**Starbird Road Condominiums**  
Project Name/Description

To: Terry Brown From: Tammy Munson  
 Fax: (207)767-1306 Pages: 1  
 Phone: (207)831-1776 Date: 04/30/04  
 Re: Starbird Road CC:

**The following** is a list of the items we need addressed on the submitted permits for Starbird Road:

**From:** <drichards@gawronturgeon.com>  
**To:** Portland.CityHall(TMM)  
**Date:** Wed, May 12, 2004 12:30 PM  
**Subject:** Starbird Condominiums

A-102

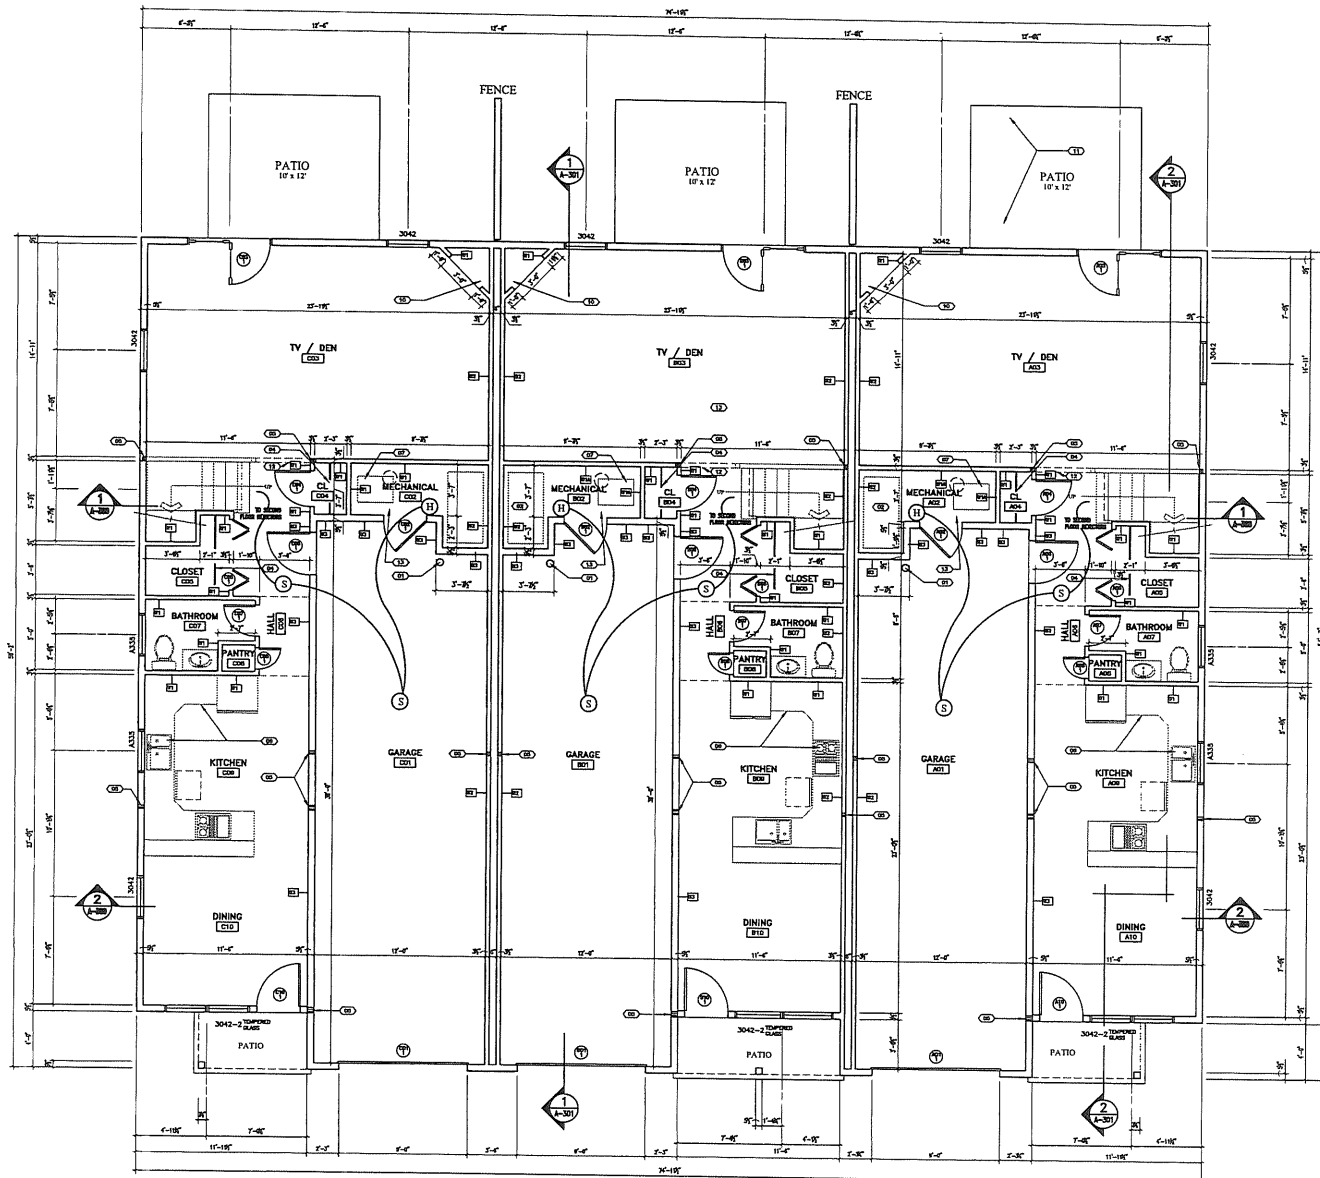
1. **Stair** details (tread, rise, headroom, etc.)
2. Attic access (two areas of the third floor) -please show size and location.
3. Weight calculations showing the third floor framing is adequate to support the HVAC equipment.
4. Smoke detector locations. - Check drawing -
5. Clearance in chase and use.
6. Fire blocking in tenant separation wall and structural support.
- 7.

*\*Need smoke on third floor*

Per our conversation this morning we are e-mailing you 6 PDF files which address the concerns posed by your review of the building permit application of the subject project.

A-300

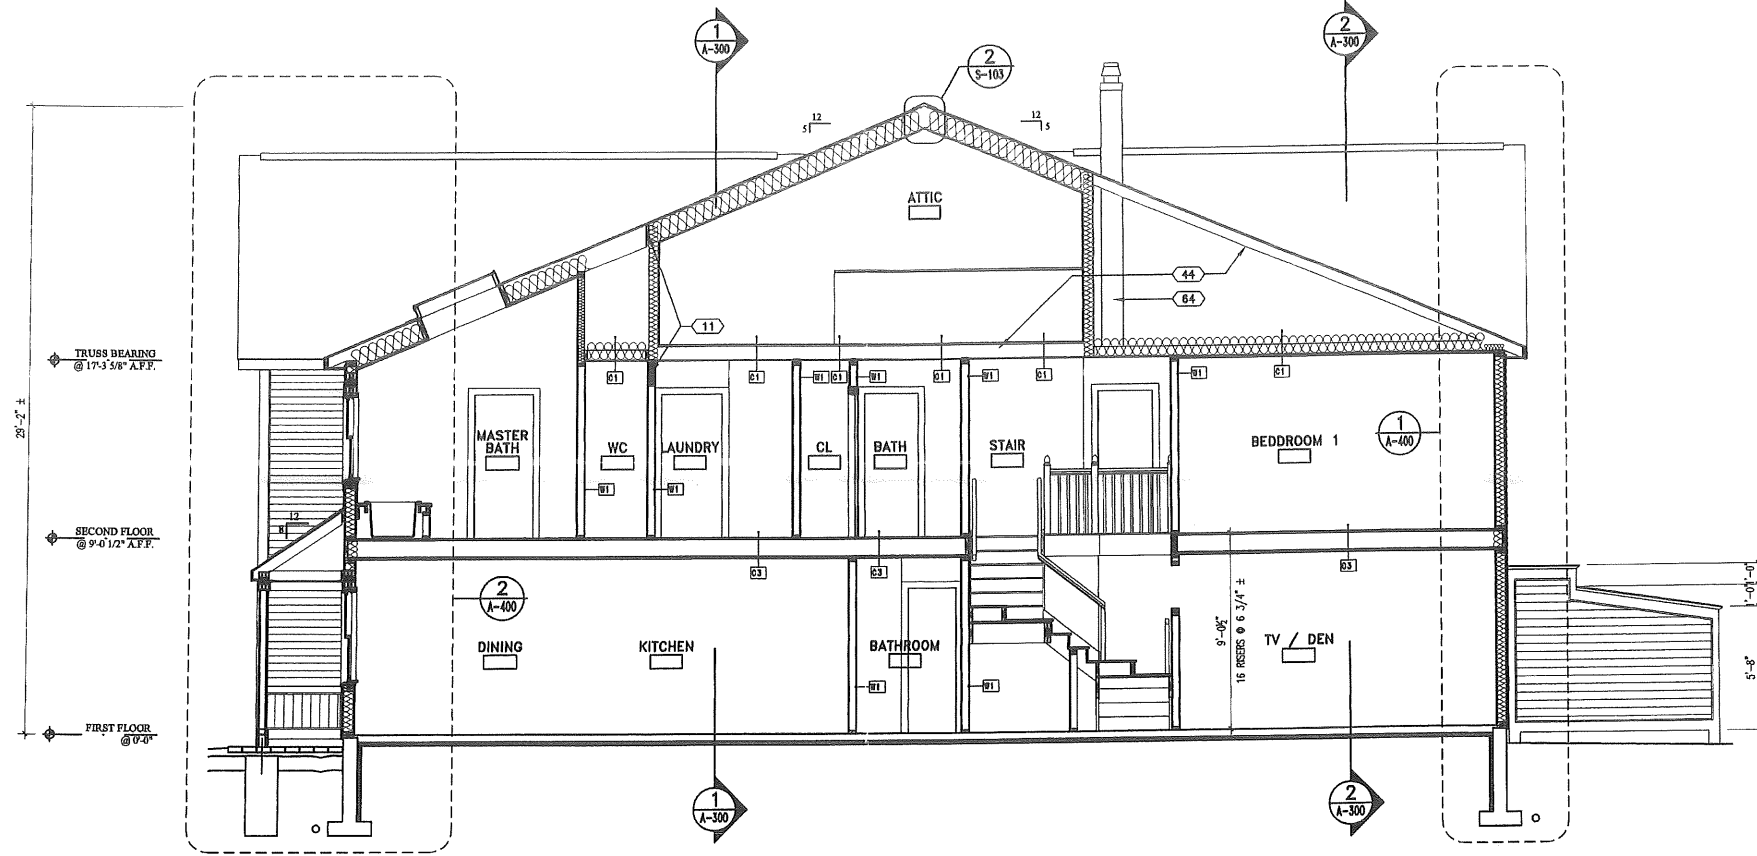
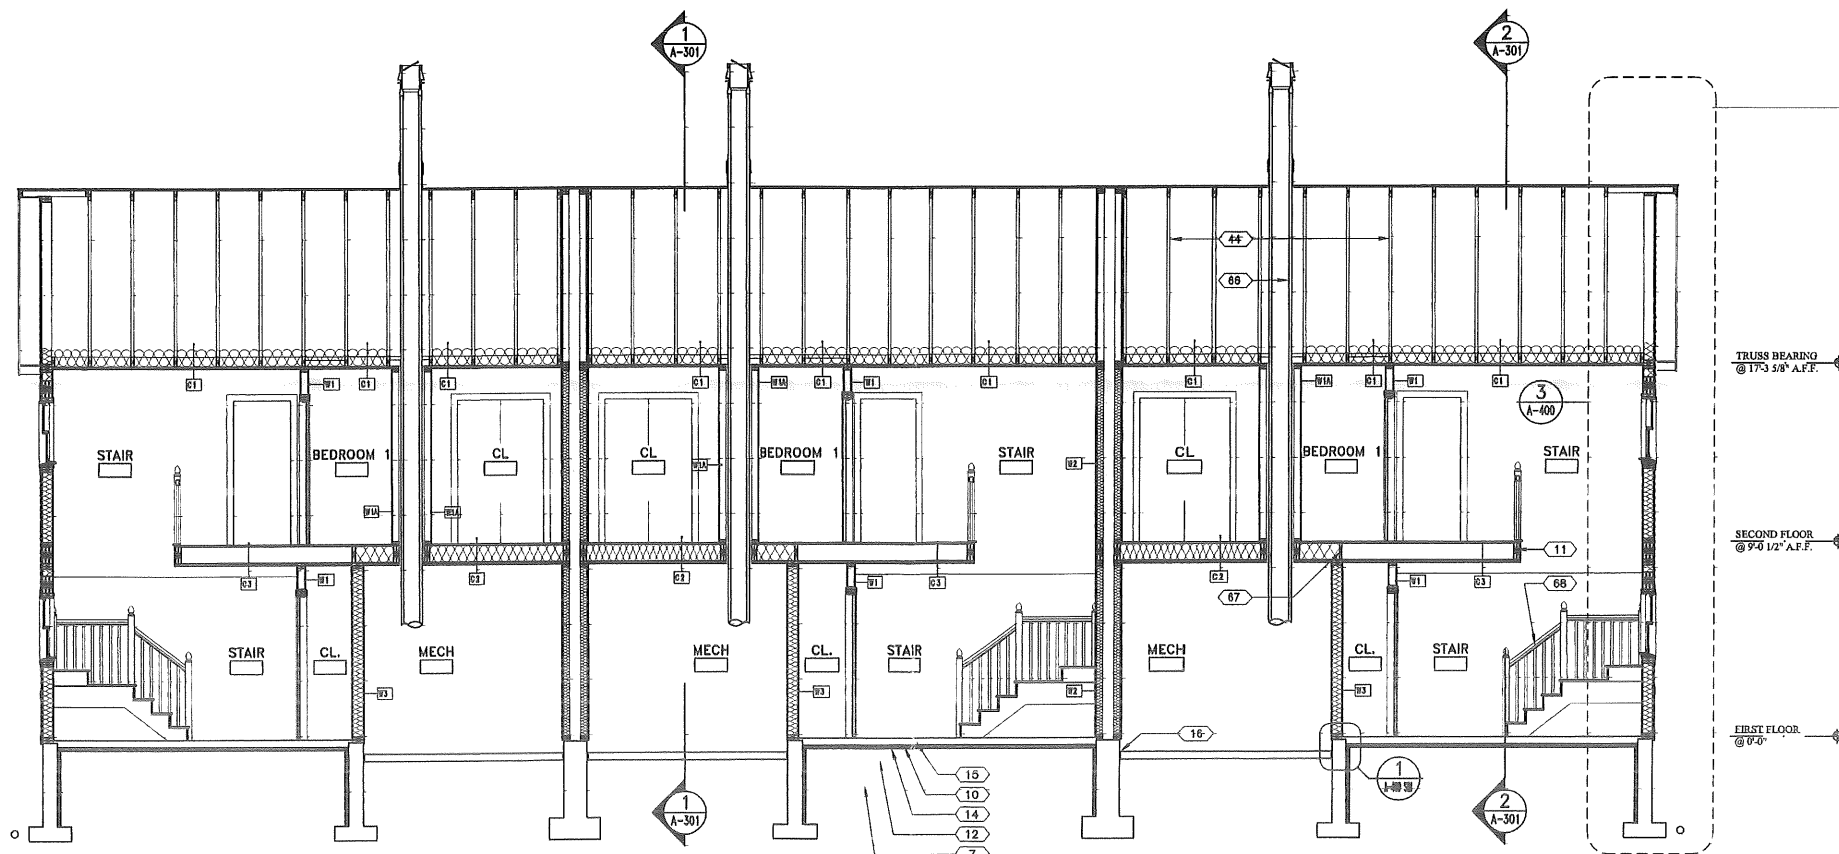
*A300-  
Double R.m.*
